Your Ref: OWPC6272
Our Ref: R/141/15/PL 08-06-2015
Please ask for:
Mr D Easton

Removal of existing balcony panels & replacement with new glass panels.
Flint House 8 Cudlow Garden Rustington

Drawing No:	15/05/2015	Date:	15th MAY 2015
Description:	BALCONY BALUSTRADE	Finish:	GALVANISED, PPC.
Project:	MR MARTIN

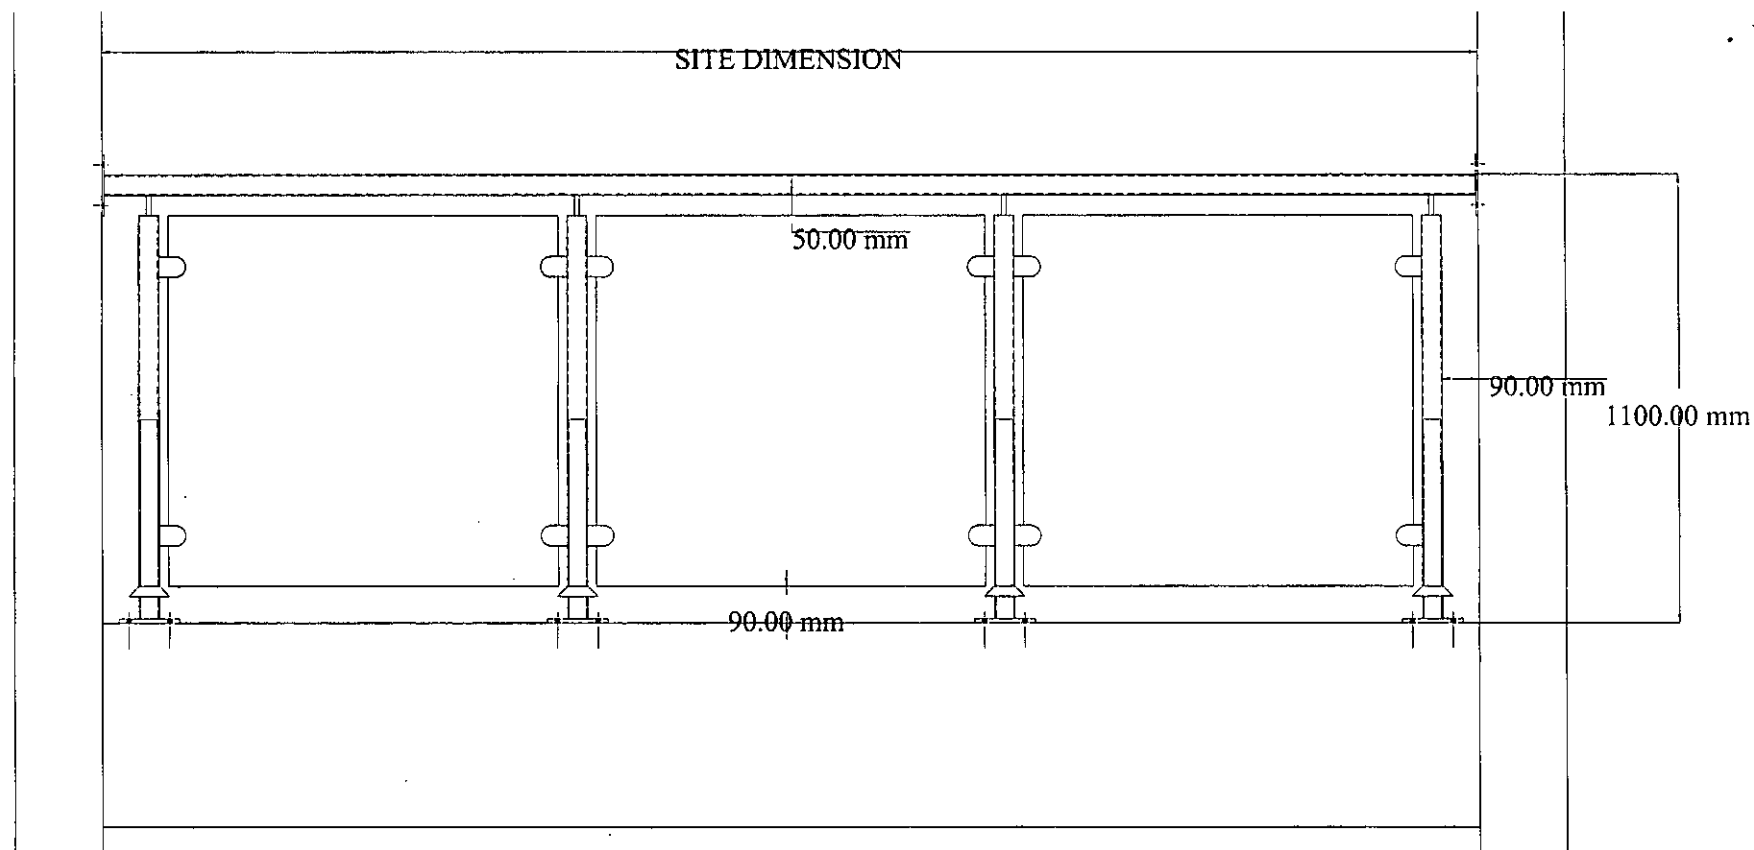
Although I understand the need to replace the balcony railings I think that the choice of replacement, i.e. chrome and glass is highly inappropriate for these buildings and will look totally out of place.

These are flats which were built in the 1960's and are in my opinion not "modern" in the true sense of the word. Furthermore the panes of glass will require an increased level of maintenance to keep then clean.

Therefore a choice which is more sympathetic to the type of balcony railings in place (and yet conforms to current building and safety standards) would be better.
